20/06/2022

An Bórd Pleanála,  
64 Marlborough Street,  
Dublin 1,  
D01 V902

Re: Great Connell SHD: ABP Reference: 313306. Applicant: Aston Ltd.  
(Also referenced as ABP-311390-21 in the Applicant's cover letter)  
Observation on behalf of Paul & Wendy Aitken, and other residents (as per attached signature pages) of Wellesley Manor Estate, Newbridge, Co. Kildare.

Fig. 15: Key map identifying the heights of existing buildings and those within the proposed scheme.

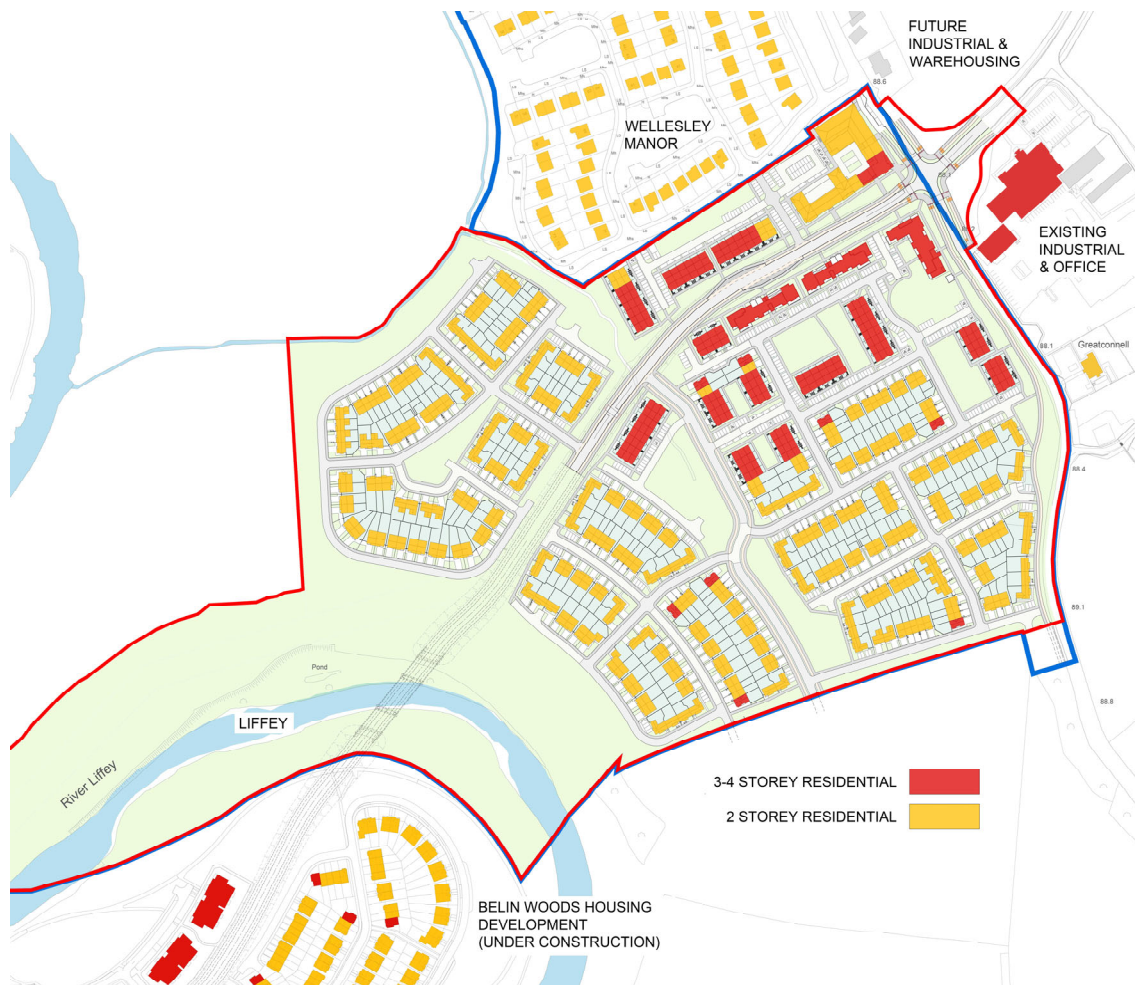
We further note that on Figure 15 on page 28 of the Architectural Design Statement, a significant part of the Neighbourhood centre is labelled '2 storey residential' which is clearly not the case.

SITE LAYOUT PLAN—SHEET 1 @ 1:500

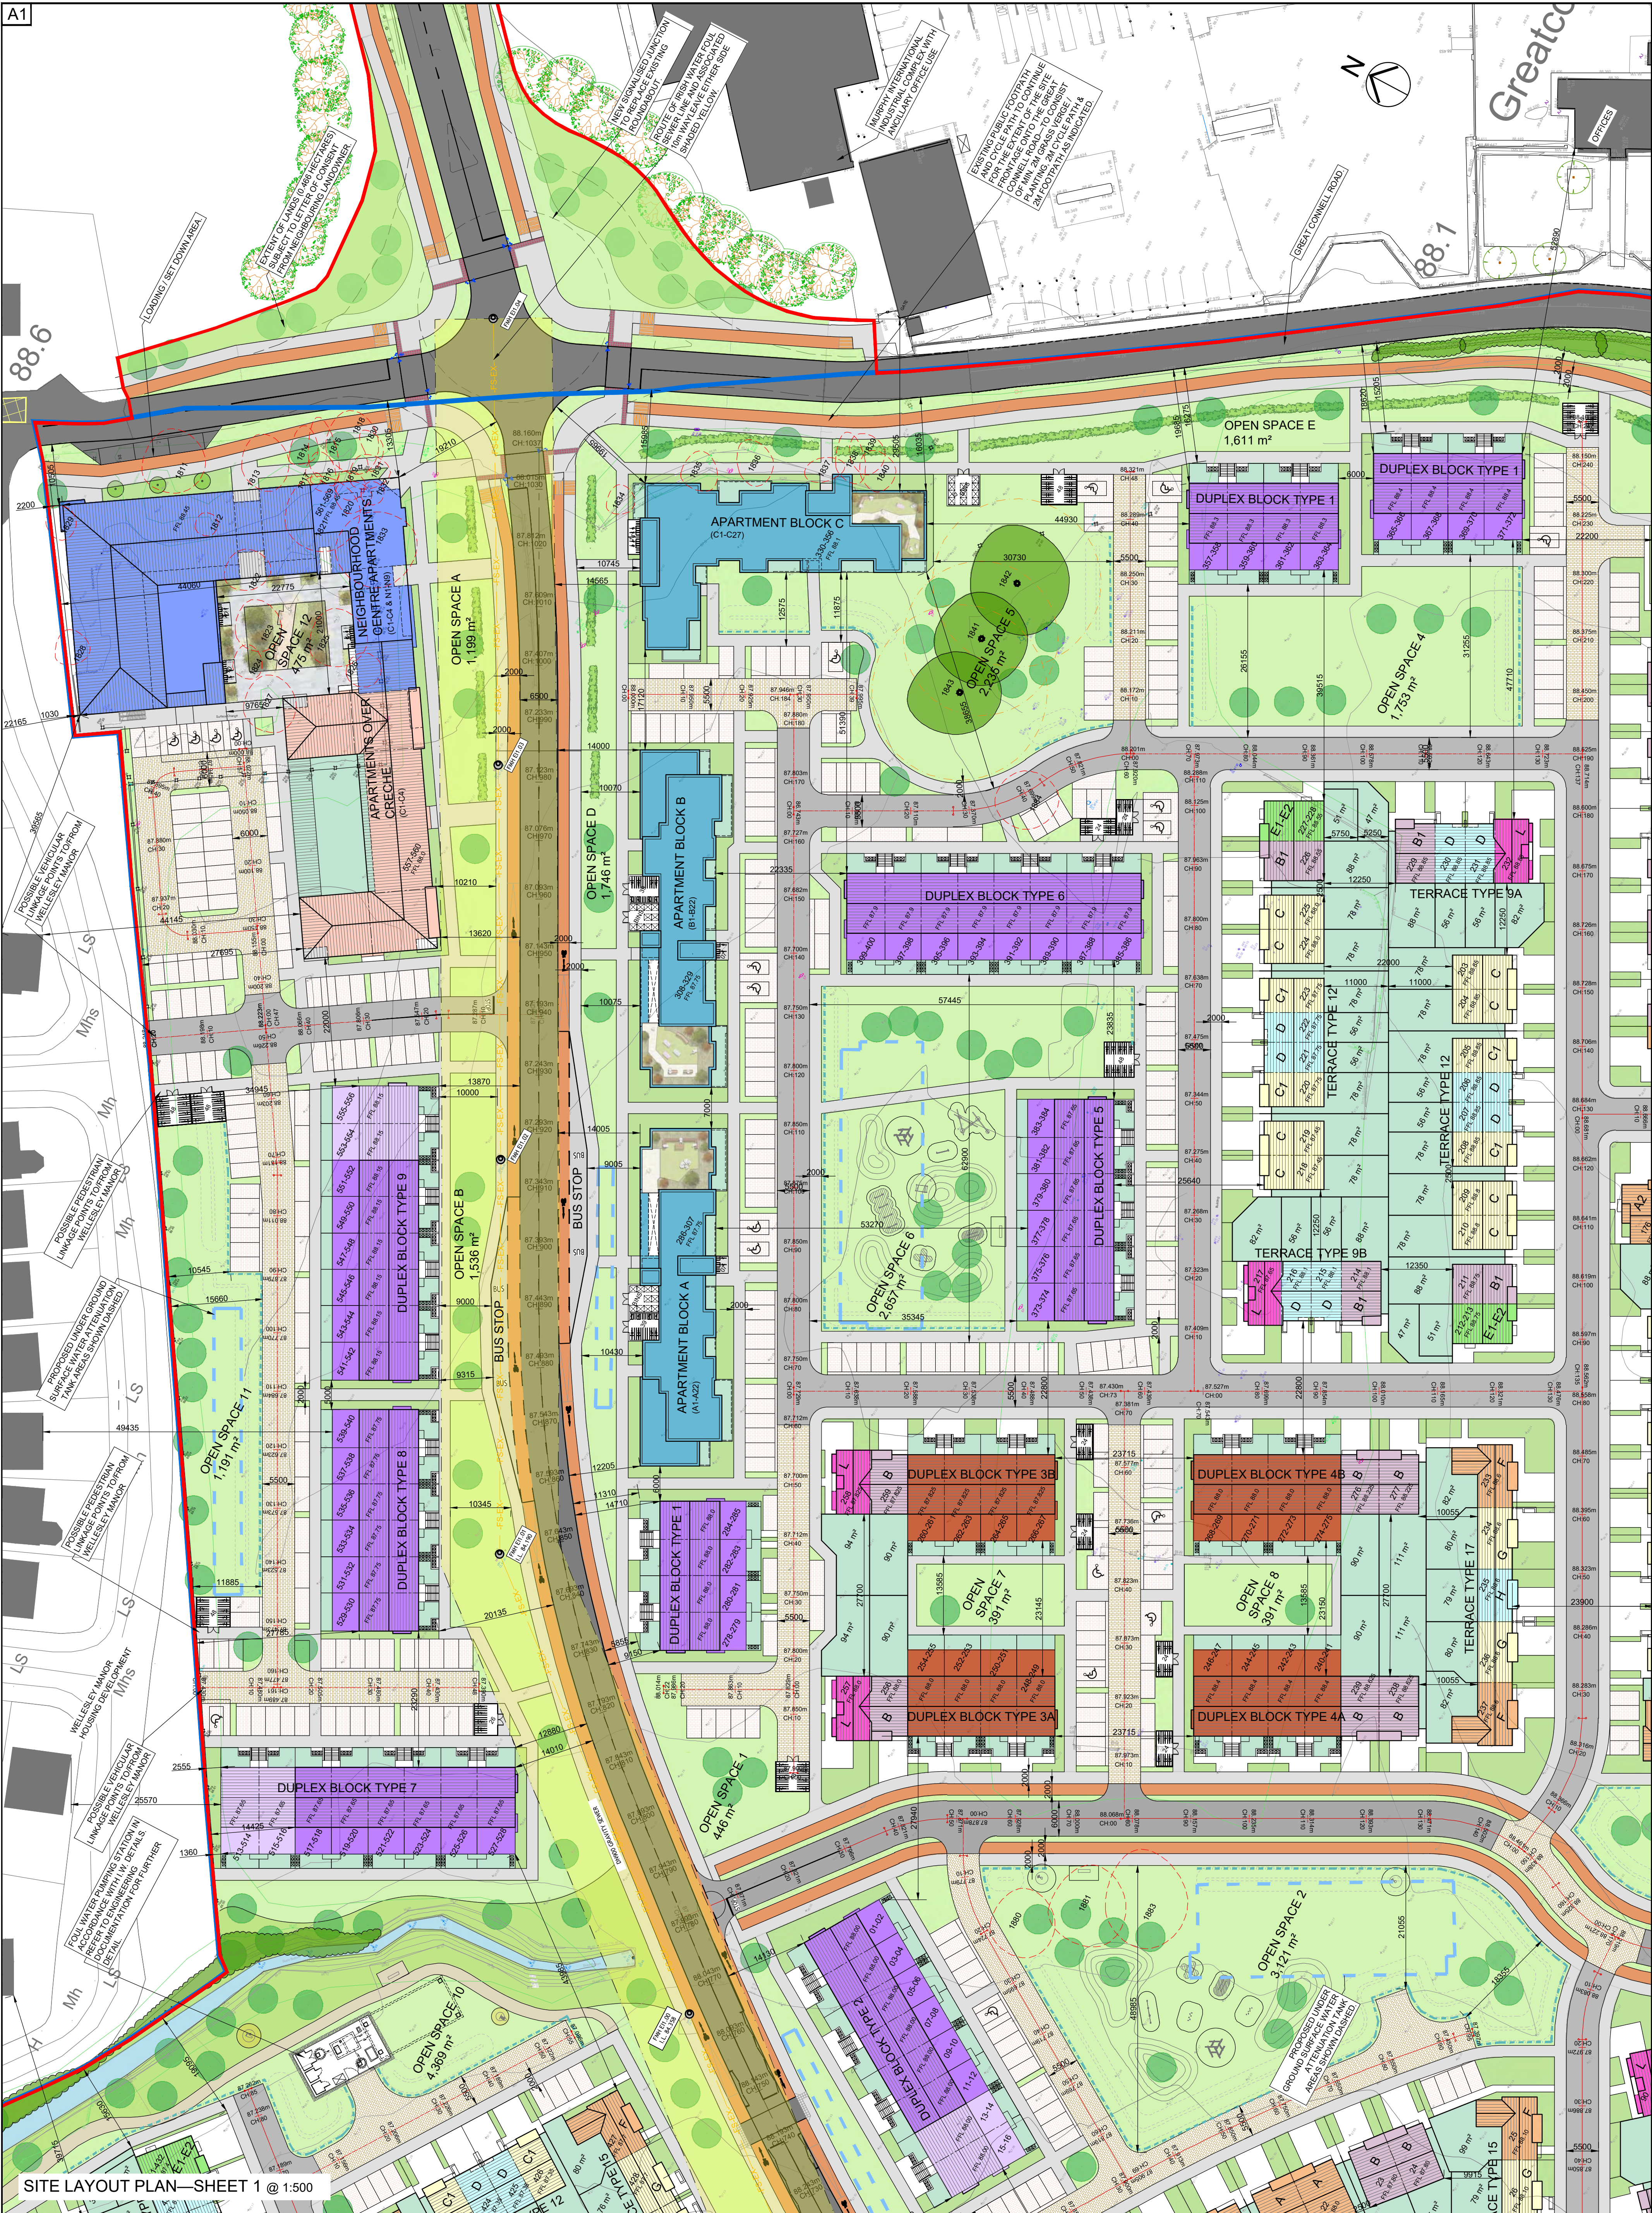
PA-003\_PROPOSED SITE LAYOUT PLAN—SHEET 1

We submit that there appears to be a discrepancy between the Proposed Site Layout Drawing and Section P-P (Part 1 of 2) in relation to the distance between Duplex Block 8 and the rear of the houses in Wellesley Manor: On the former, a dimension of 67330 is given, whereas we calculate the distance to be in the order of 53100. Should we be correct in this assertion, the representation of the proximity of the proposed development to the existing houses in Wellesley Manor is understated by over 14 metres: this is both significant for the owners in Wellesley Manor who may be relying on these drawings to ground their opinion on the scheme, but is also 'material' from a Planning perspective. It is unhelpful, and may be 'material', that the distance of Block 8 from the site boundary is not indicated on this drawing.

We submit that the accuracy of the drawings must be called into question and would respectfully request An Bórd to consider whether the application can be considered valid in such circumstances.
